ENG-SF21021-R2-FDR.pdf Markup Summary

Engineering Review
12/10/2021 12:53:01 PM
dsdrice
JedRice@epcd.org
719-528-7977
EPC Planning & Community
Development Department

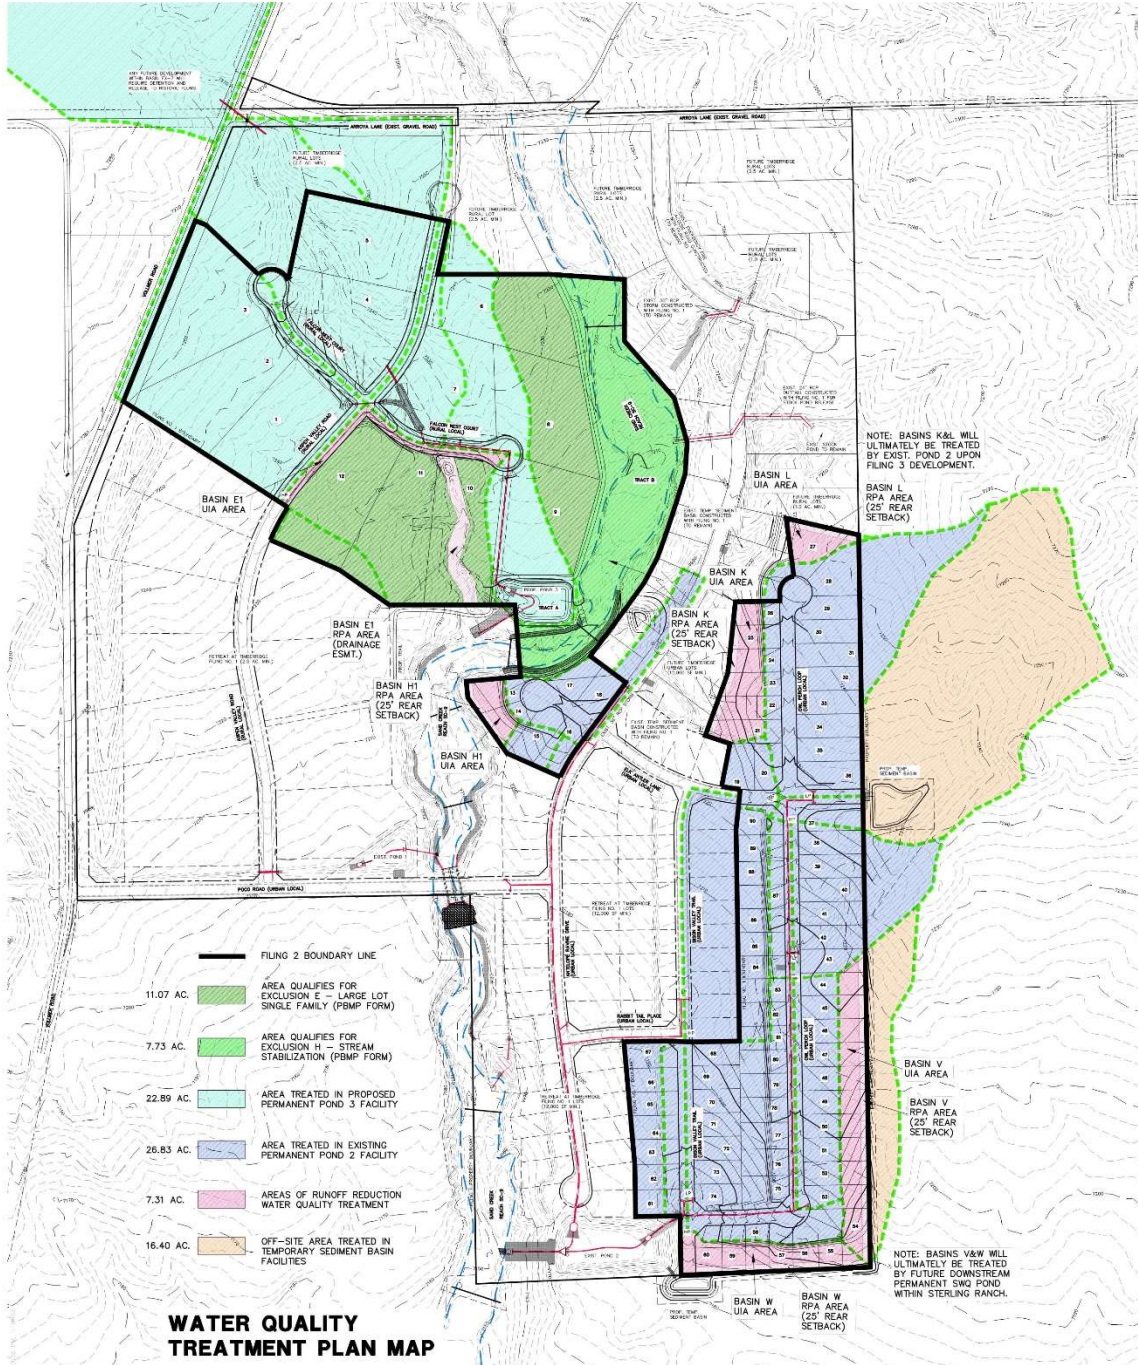
provide a figure showing all proposed UIA and RPA areas to be utilized for runoff reduction. All RPA areas will need to be within a no build/drainage easement and discussed in the maintenance agreement and O&M Manual.

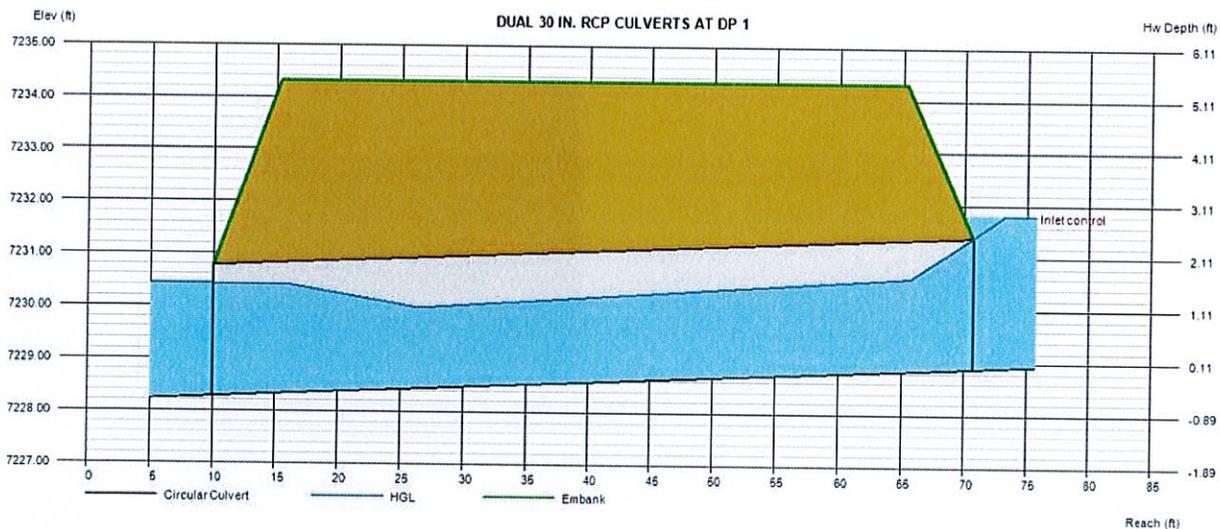
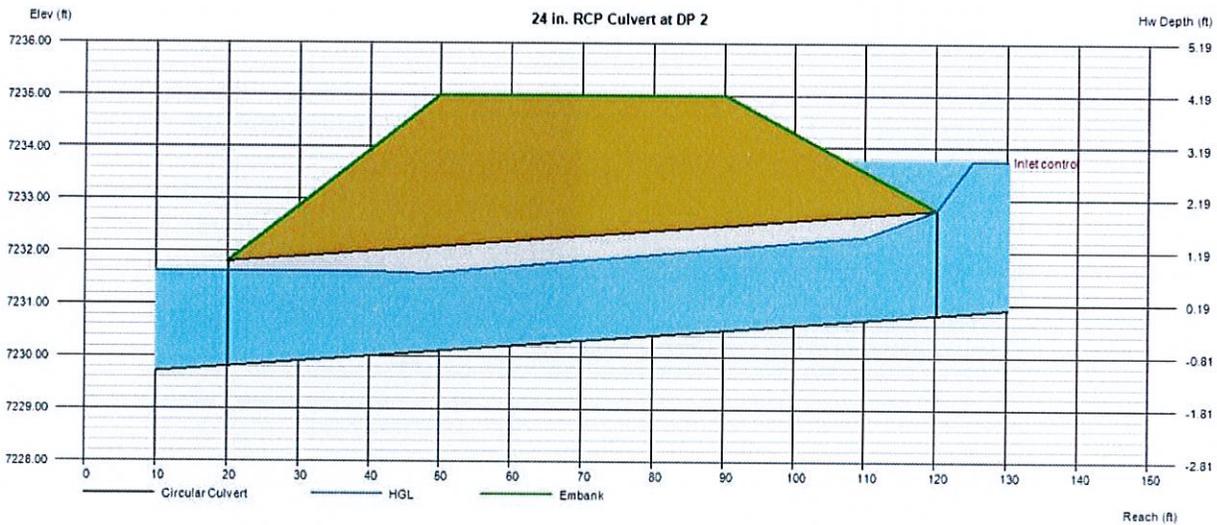
Include calculations for RR outlet protection, unless installed with Filing 1. If so, please note that in report and remove reference to rr calculations in report.

Proposed Channel within Lot 7 - North side of Falcon Nest Ct.

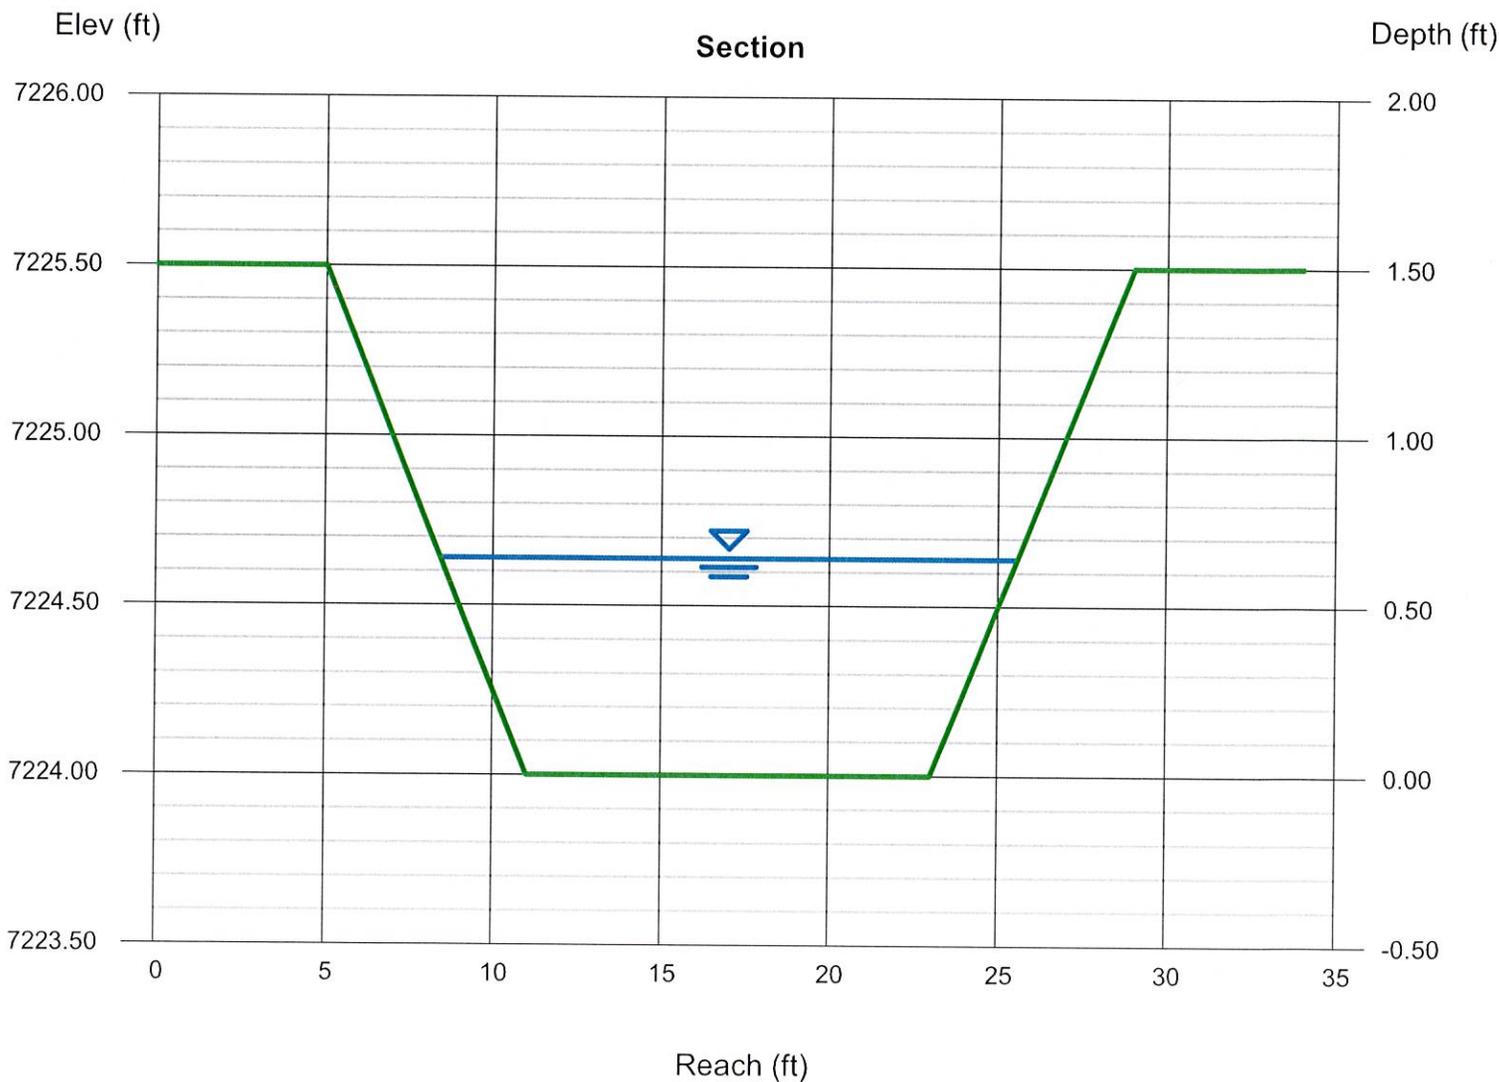
Total channel depth needs to be 1.64' min (0.64' + 1.0' freeboard). Please increase channel depth by 0.15'

Sand Creek SC-9

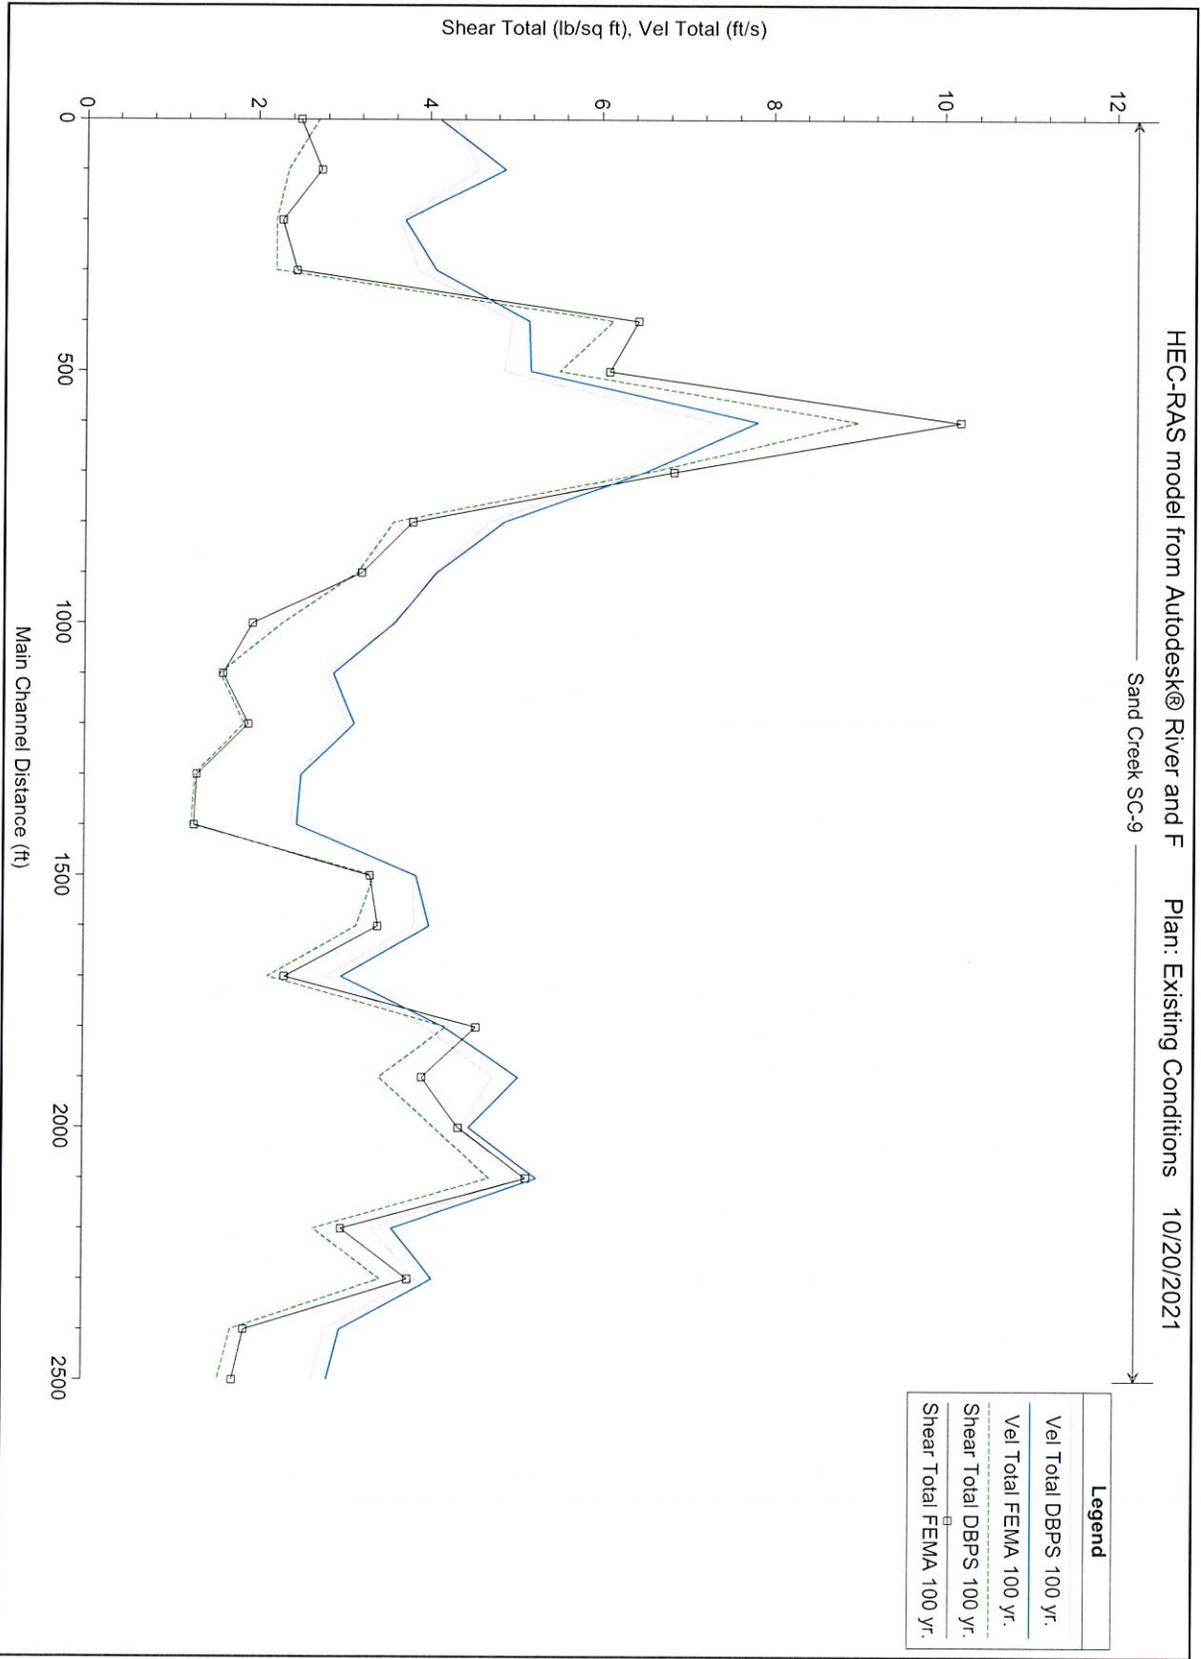
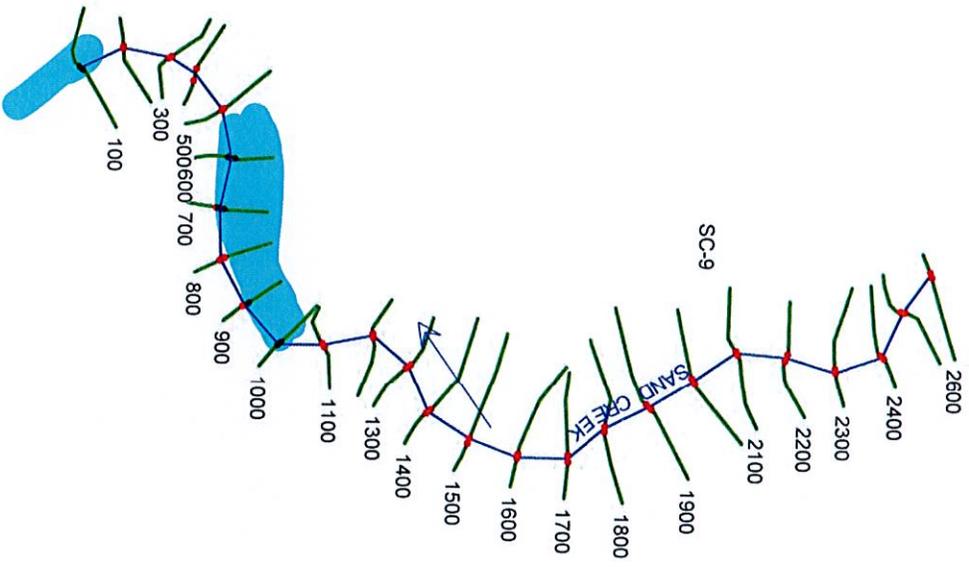
Grade control required?

MHFD has acceptable criteria; address channel design and stability.

These (and 2 above) are still very high
